WILLOW SPRINGS RANCH FILING NO. 2

CONSTRUCTION DRAWINGS

PCD FILE NO. CDR224

STREET CONSTRUCTION DOCUMENTS FOR:
WILLOW SPRINGS RANCH
FILING NO. 2
BAPTIST ROAD & FOREST LAKES DRIVE
MONUMENT, COLORADO

**NTS**

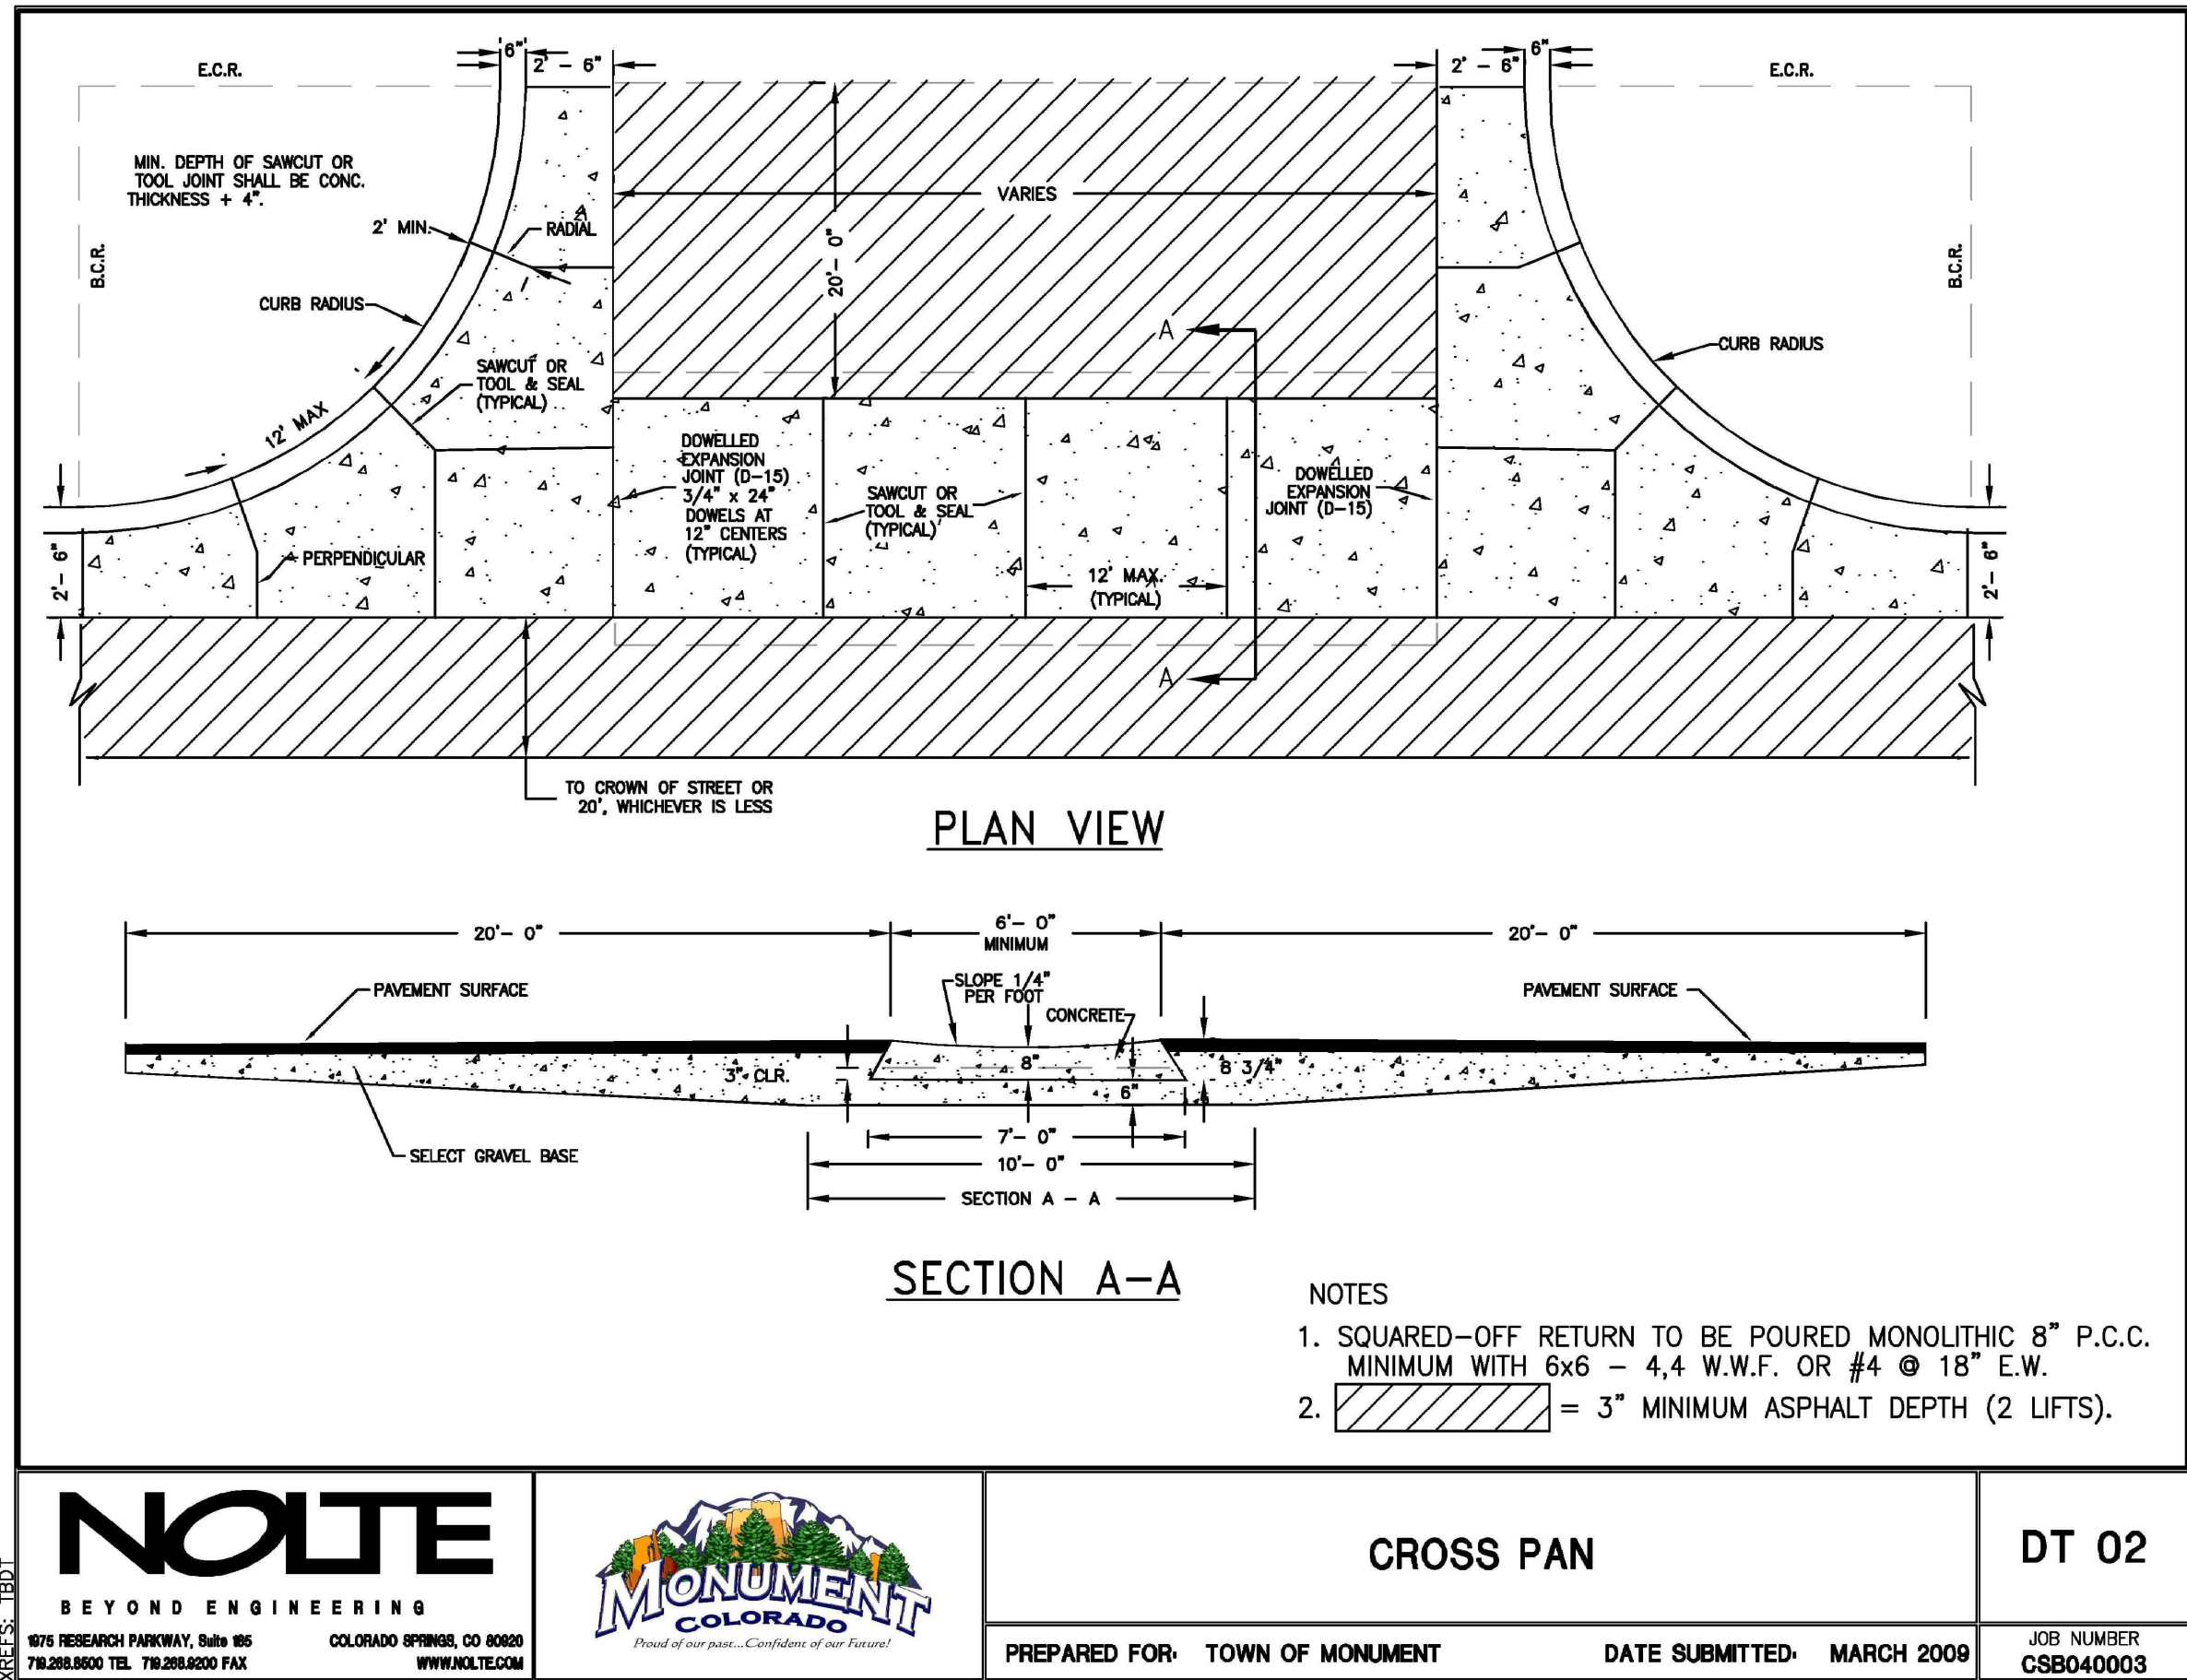
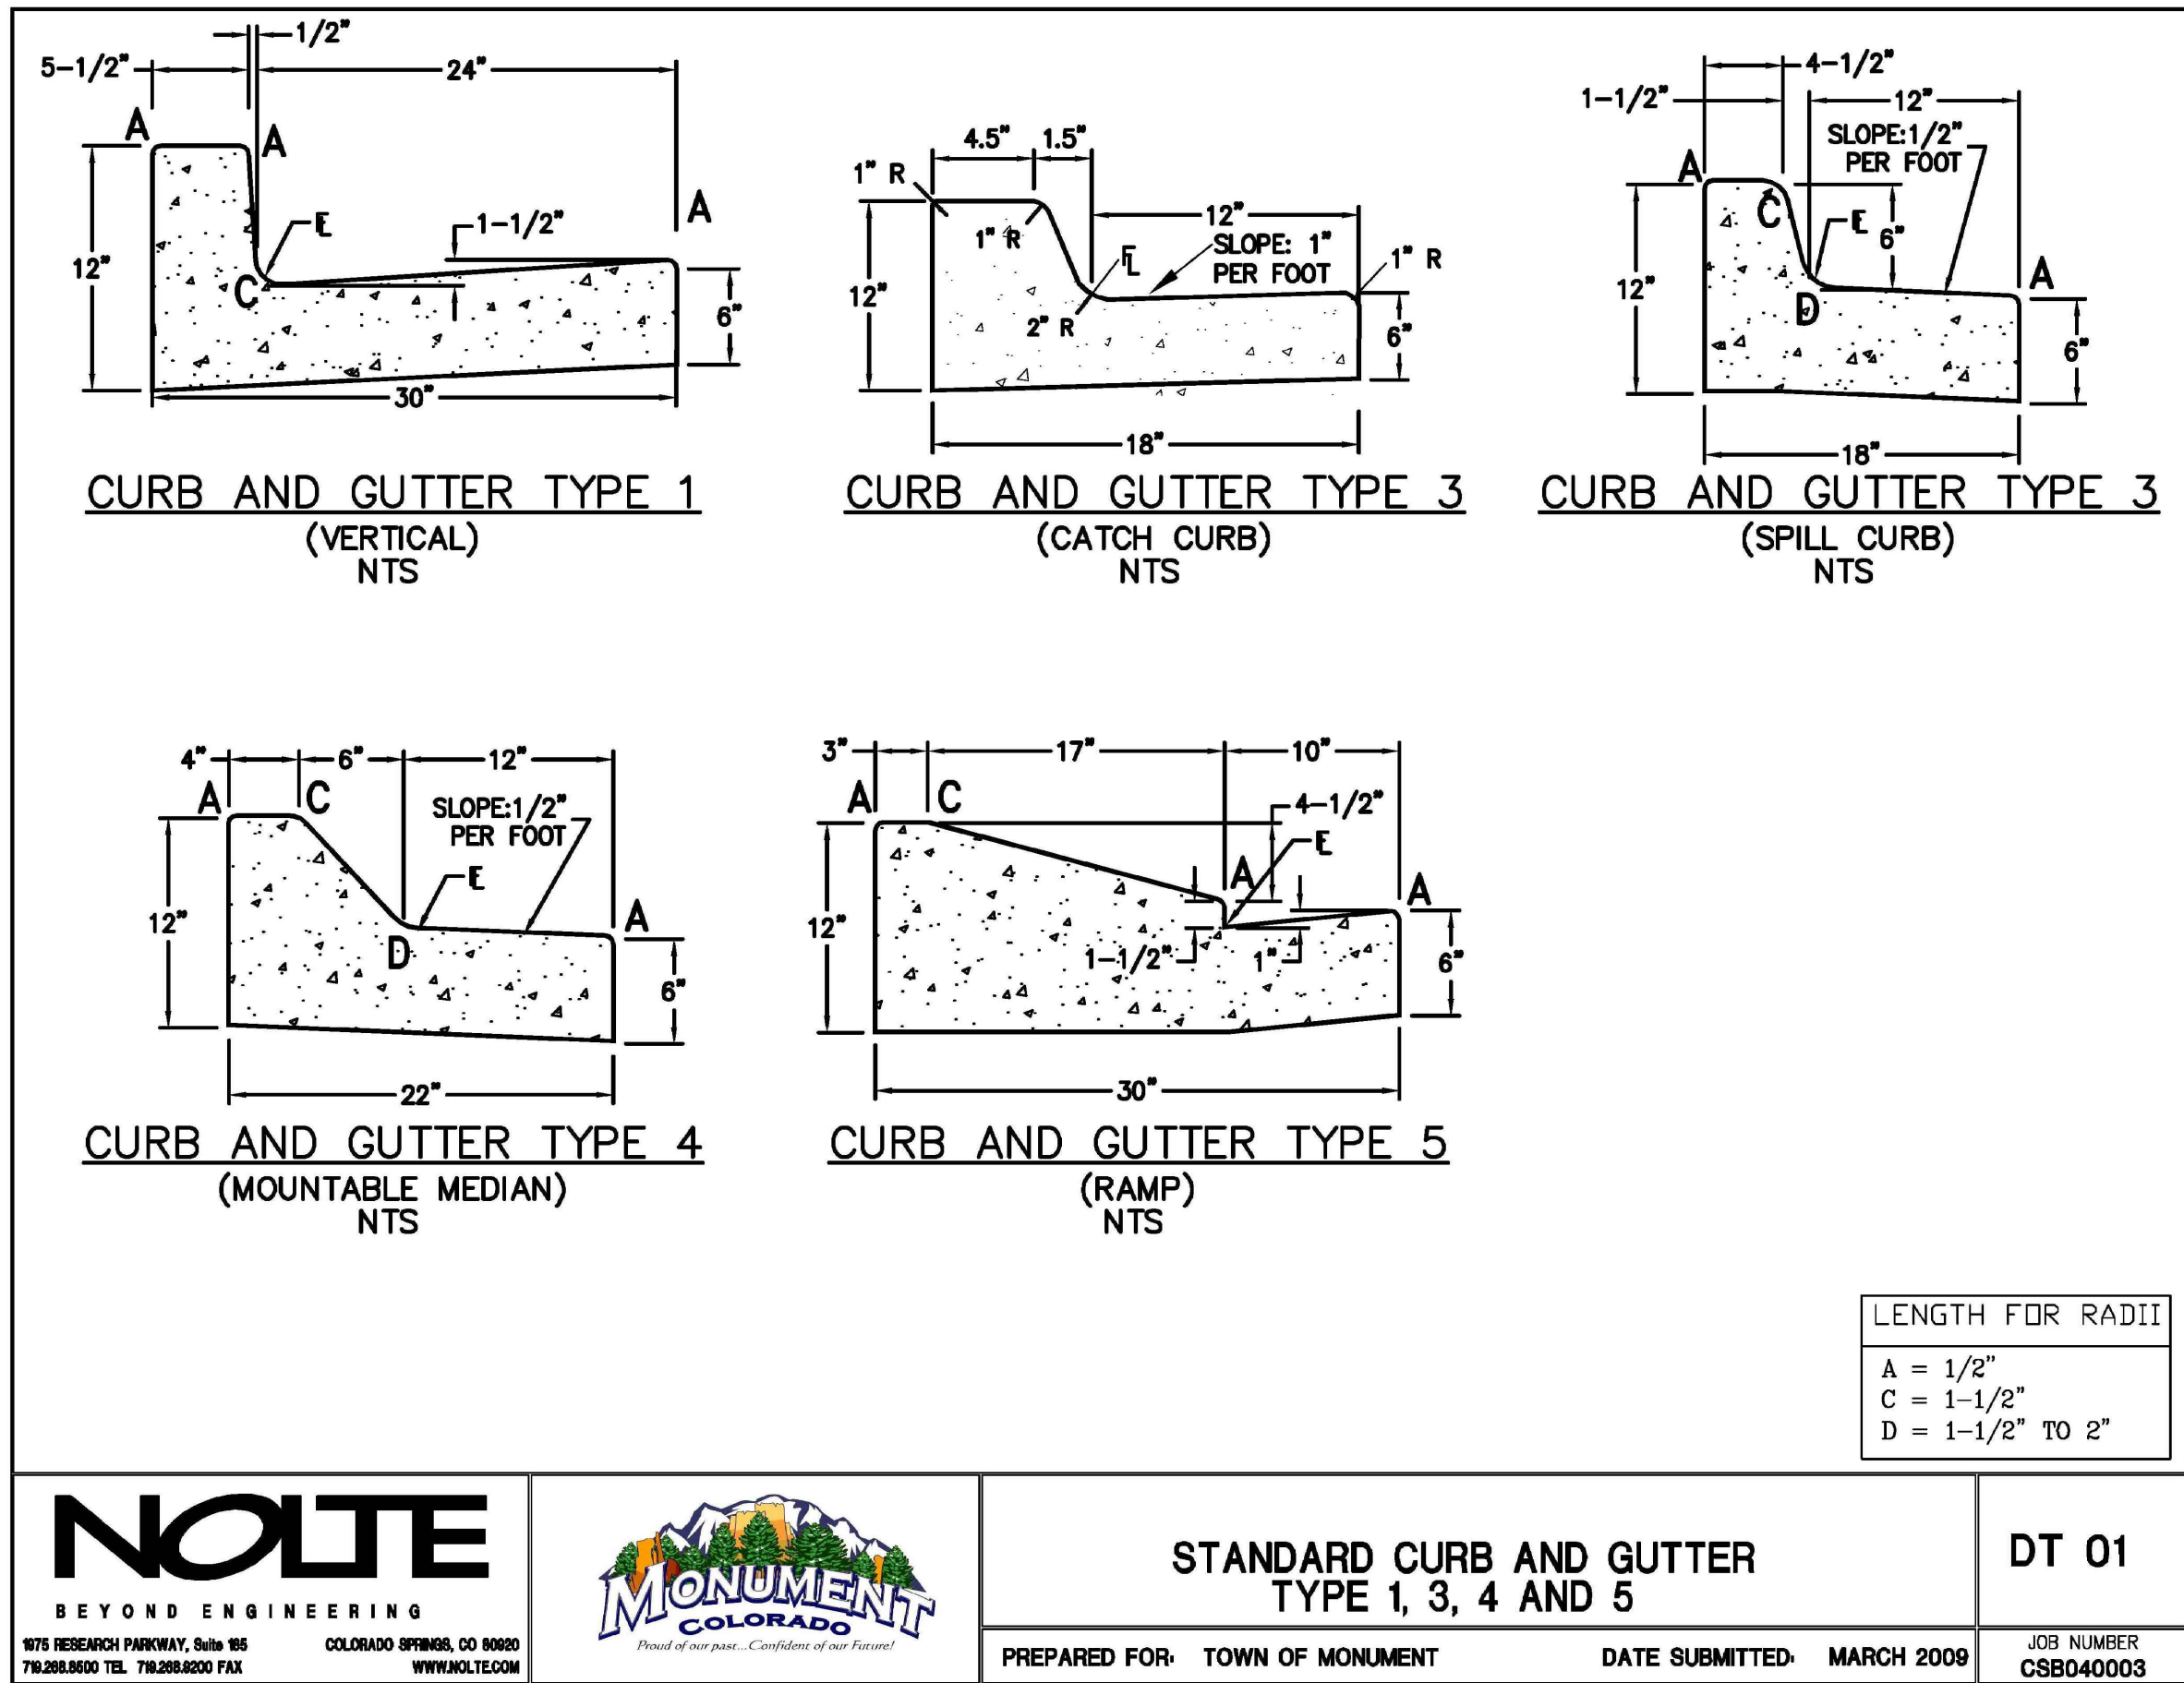
Detail sheet has been modified to replace the Pedestrian ramp details SD_2-40, SD_2-41, and SD_2-42 with the latest version (Revision Date: 6/23/20) to be used for construction of the pedestrian ramps within El Paso County ROW (Forest Lakes Drive).
